Application No: EP/35/21/HH
Site Address: 46 Manor Road East Preston BN16 1PY
Description of works: Rear extension, associated works, new porch, replacement of fenestration and erection of solar panel array.

Thank you for your internet representation made on 19th May 2021 which has been recorded as an objection with the comments as follows:

The committee agreed to object to this Planning Application - if possible - on the grounds very little greenery is being left in the rear garden and this does not sit well with the council's policy to make the village more environmentally-friendly.

Landscaping Plan -
Proposed

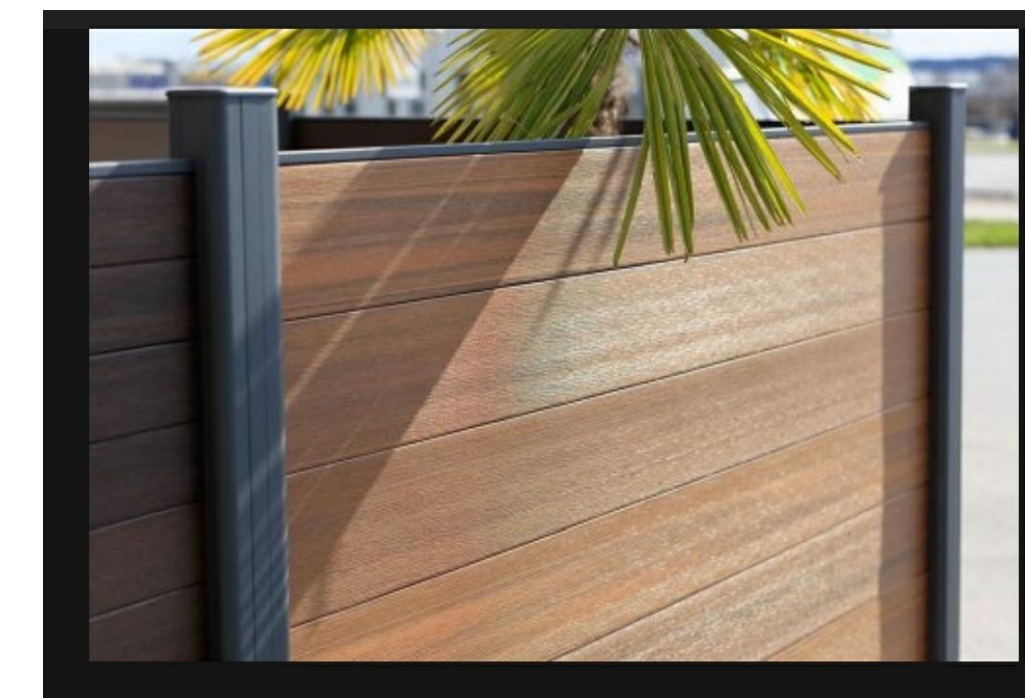
For this reason alone, this council asks ADC to consider refusal Planning Permission for this Application.
